COLORADO SPRINGS UTILITIES 2021 NE GRAVEL STAGING AREA RELOCATION

7723 NORTH CAREFREE CIRCLE
COLORADO SPRINGS, COLORADO

C1.01

GENERAL INFORMATION
Please add PCD File No. PPE-21-0507

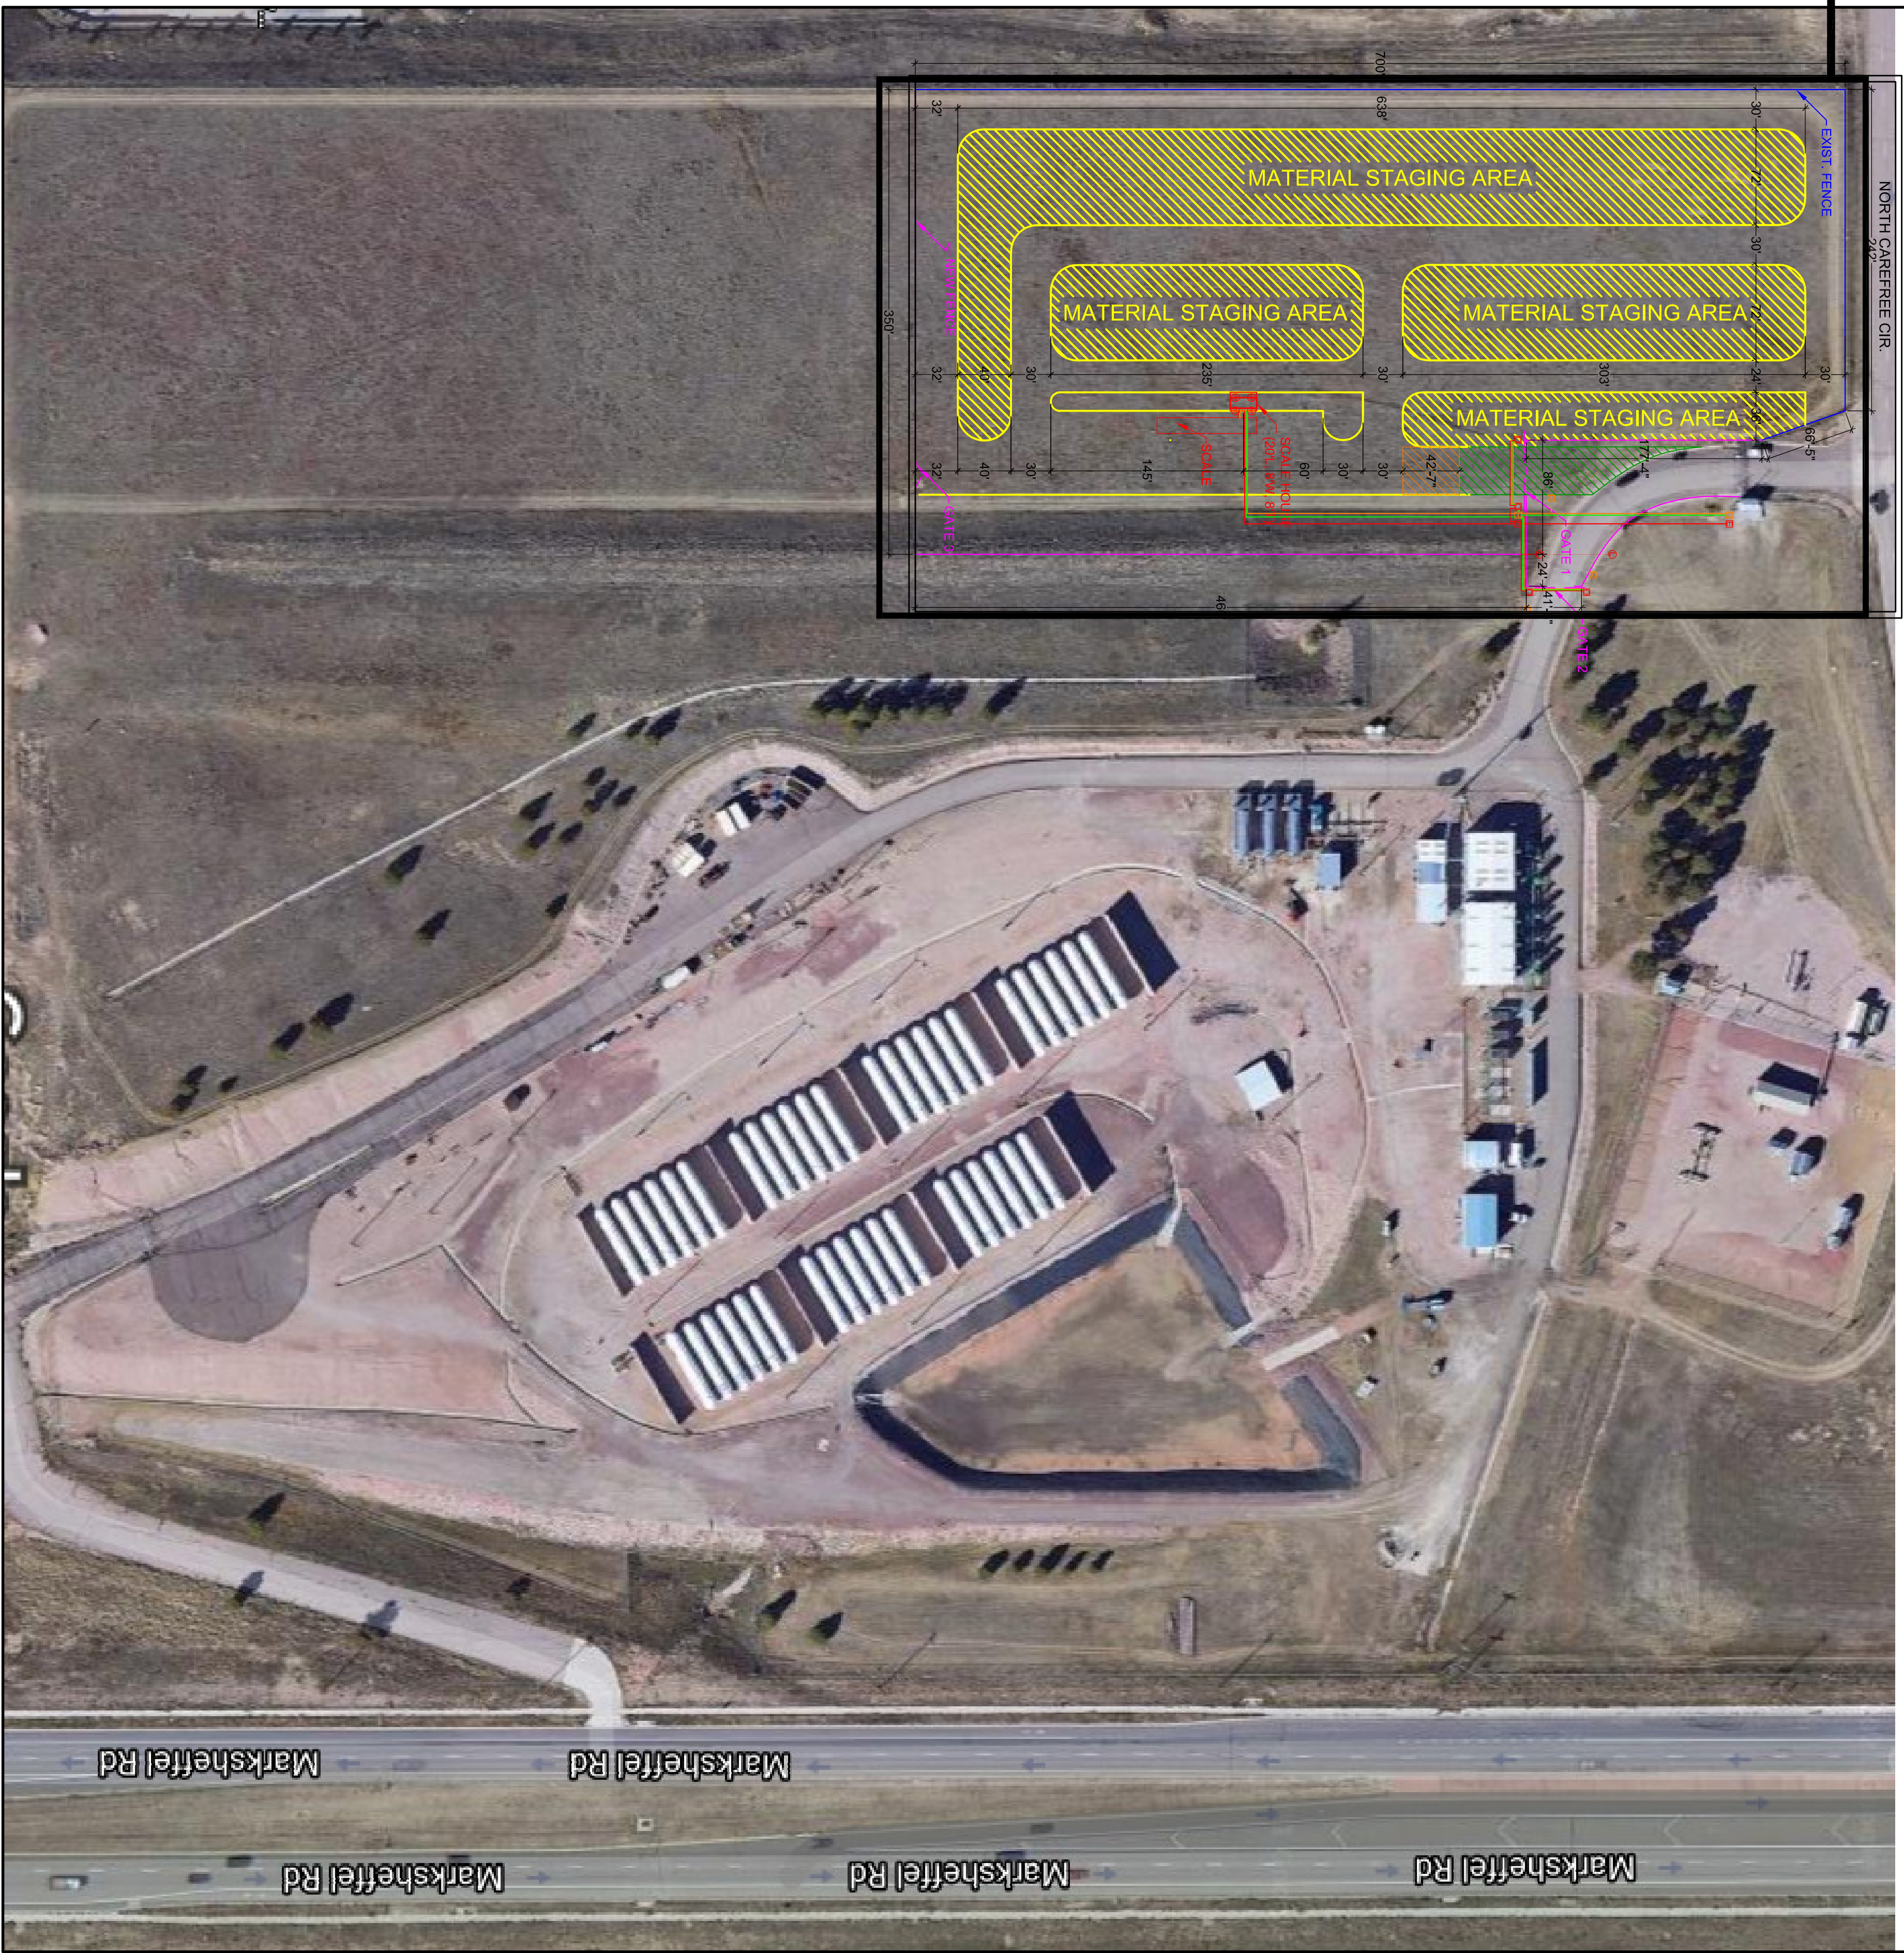
Please add a legend for all line types and symbols.

Please show and label county right of way.

Include a summary table with the following information:

- Owner name, contact telephone number, and email for responsible party
- Applicant name (if not owner), contact telephone number, and email for responsible party
- Plan preparer name, telephone number, and email
- Property address
- Property tax schedule number
- Legal description
- Lot/parcel size
- Lot area coverage calculation
- Existing/proposed land use and zoning
- Total gross building square footage
- Open space, landscaping, and impermeable surface percentage
- Density and total number of dwelling units (residential)
- Parking computations (required, provided, etc.)

Include the following:

- Graphic scale
- Vicinity map showing the property in relation to the surrounding area
- Location of the property lines, right-of-way, and all existing and proposed easements

Please add the following ADA note:

Please add a scale.
